# **KITTITAS COUNTY**

## **DEPARTMENT OF PUBLIC WORKS**

### **MEMORANDUM**

**TO:** All Staff  
**FROM:** Public Works Plan Review Team  
**DATE:** July 15, 2026  
**SUBJECT:** SX-26-00011 Slade

SITE PLAN

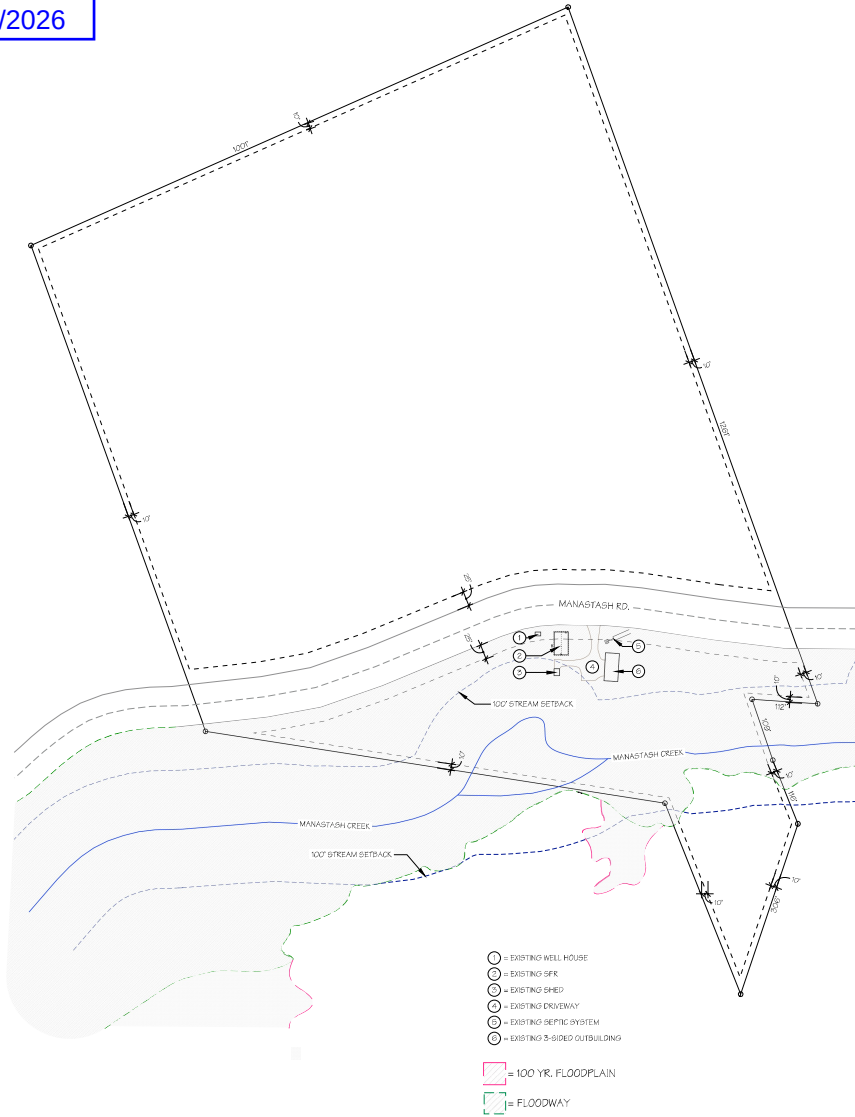
| <b>FLOOD</b>                              | Parcel #645133 is mapped within the FEMA identified special flood hazard area (100-year floodplain and floodway). Flood permit FD-26-00015 has been issued for the proposed foundation replacement.<br><br>Note: The replacement foundation and porches must be constructed within the footprint of the existing foundation and porches. Additional encroachment into the floodway is not permitted. (SC) |
